**ANGEL PLACE
LEVEL 8, 123 PITT STREET
SYDNEY NSW 2000**

2 September 2022

RESPONSE TO REQUEST FOR INFORMATION - INTERCONTINENTAL HOTEL ALTERATIONS AND ADDITIONS MODIFICATION 2 (SSD 7693 MOD 2)

PROJECT NAME		
STREET, CITY		
CLIENT - CLIENT		
TITLE		
VIEW 02-CAHIL EXPY VIEW		
JOB No	DWG No	ISSUE
6680	SD2824	04

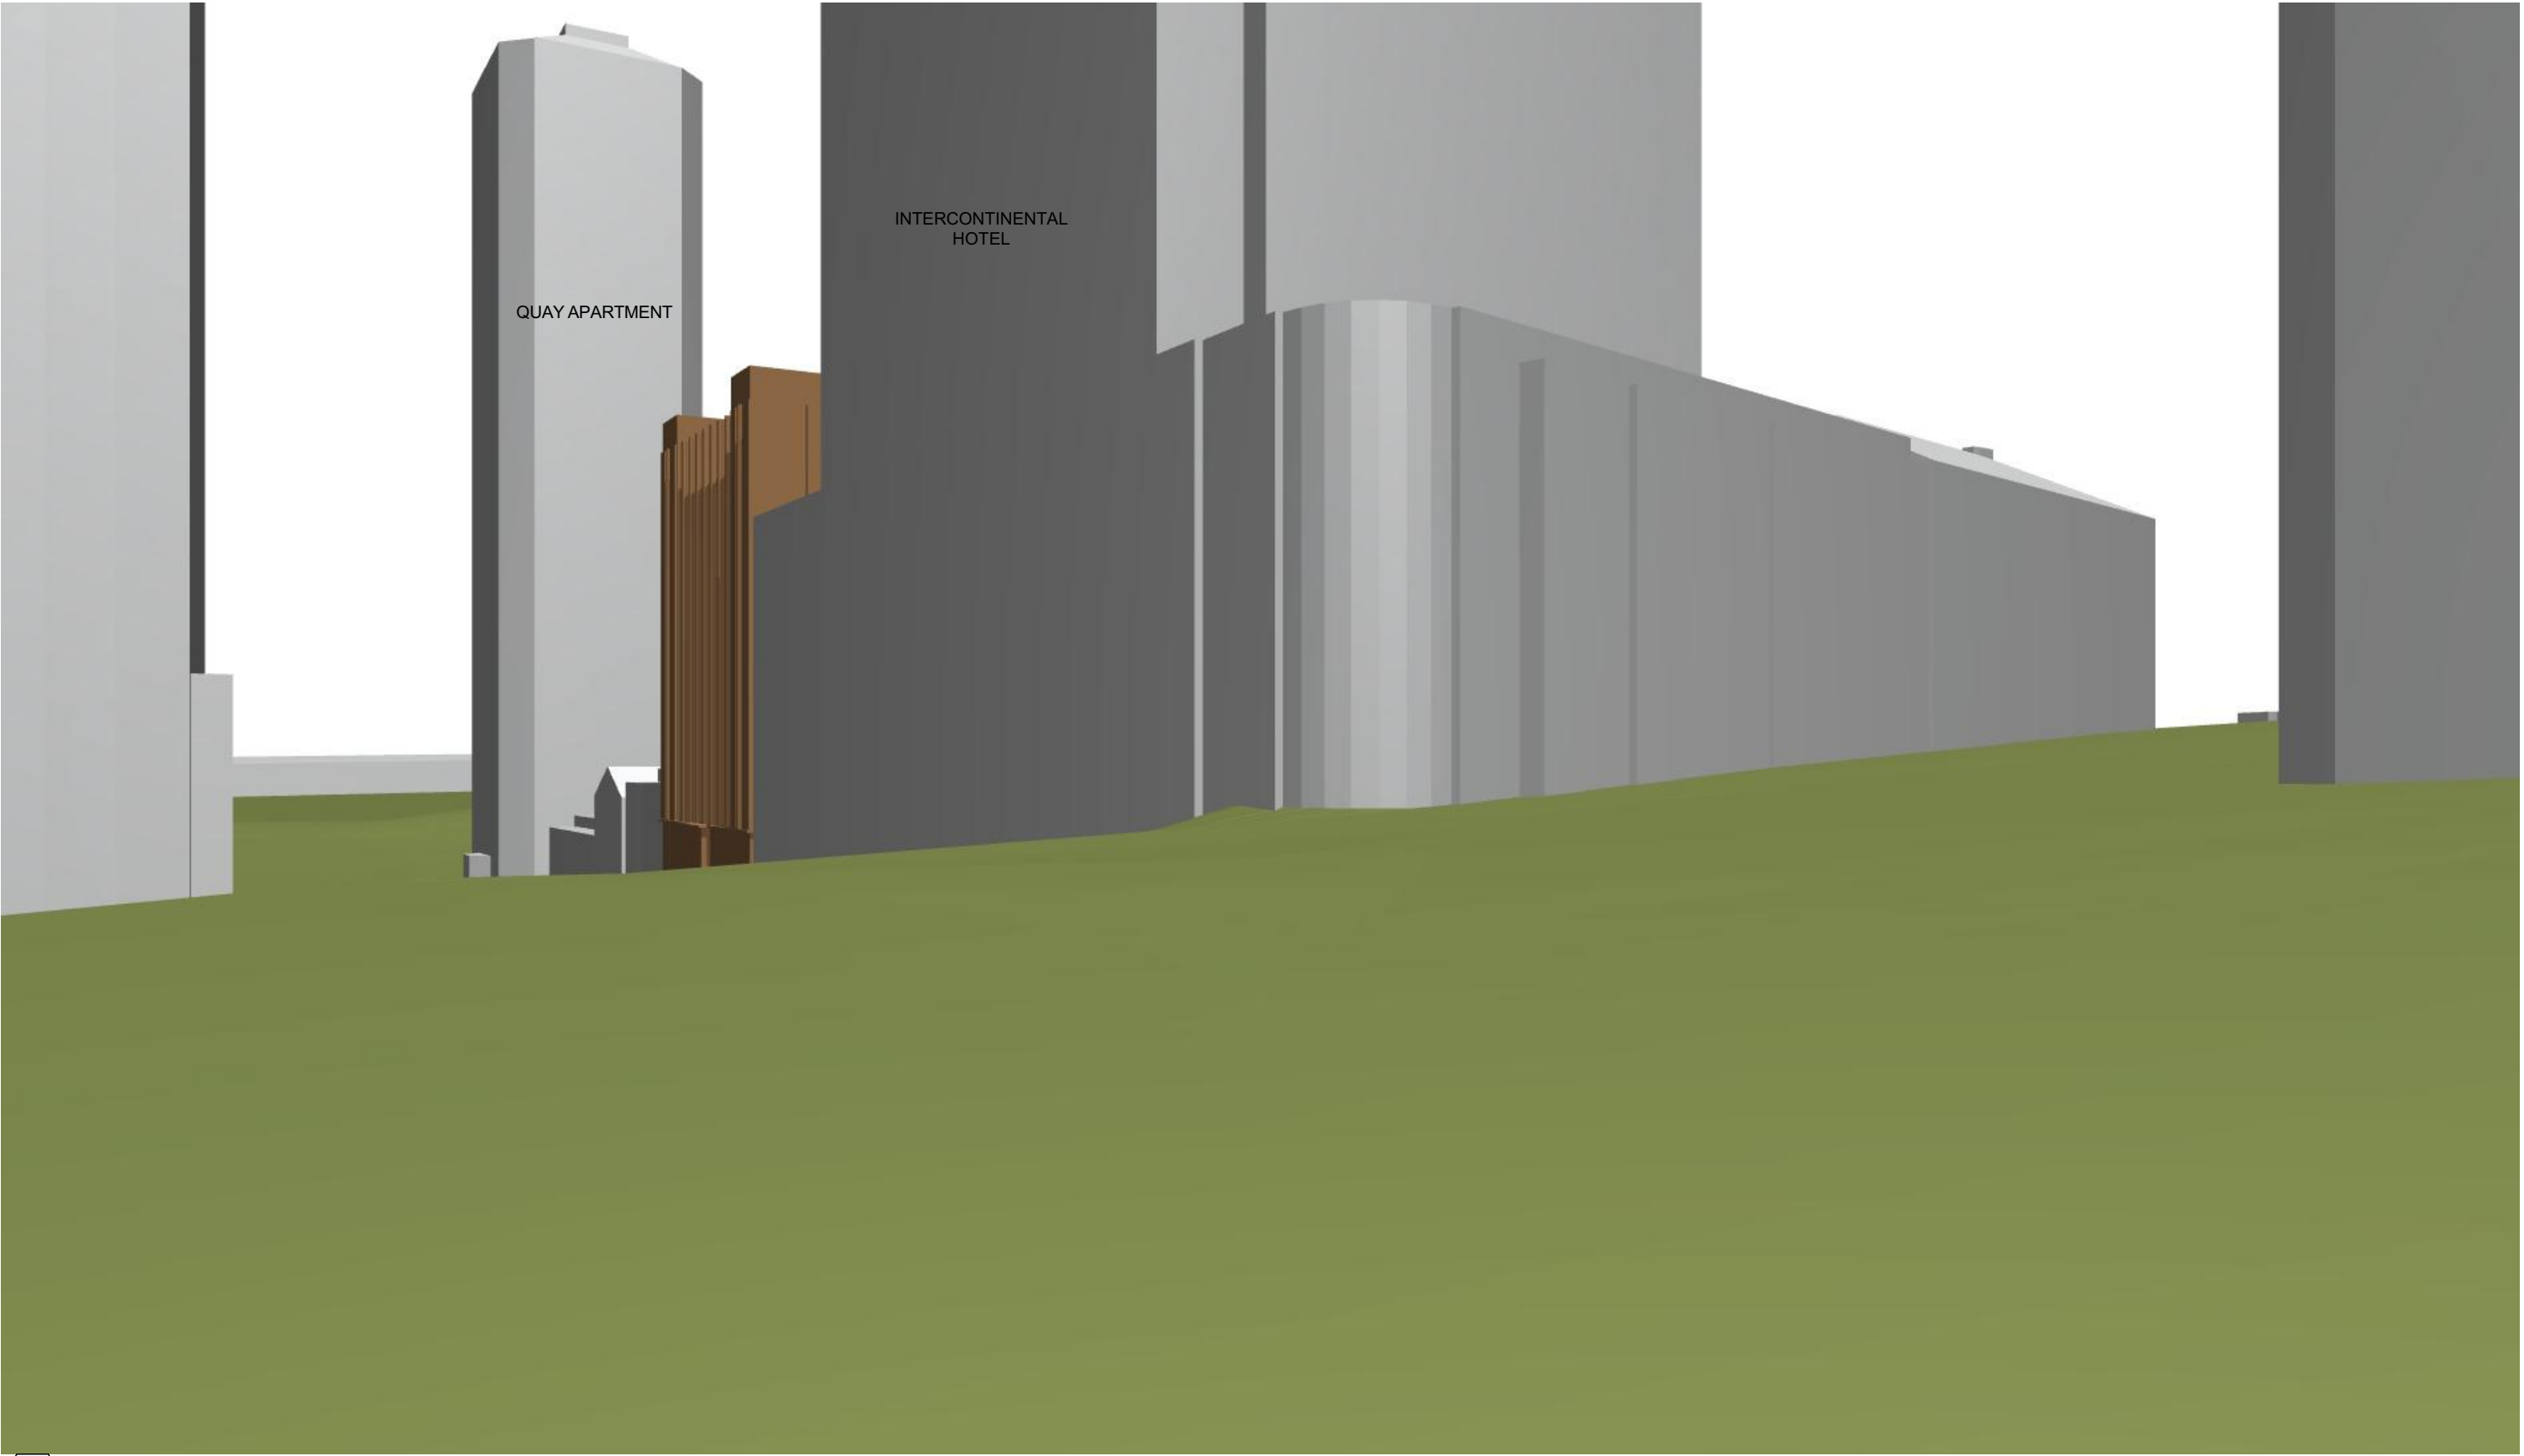
Cottee Parker have prepared a view study of the proposed Phillip Street elevation from key vantage points (Appendix A). The view study demonstrates that from key vantage points, the proposed lift connection is shielded by the existing plant deck area. Refer to the figures below.

The minor lift connection will not be visible from key vantage points and will not create any negative heritage or visual impacts. Therefore, the initial reasons for approval remain valid and this minor modification will not have any consequential environmental impacts.
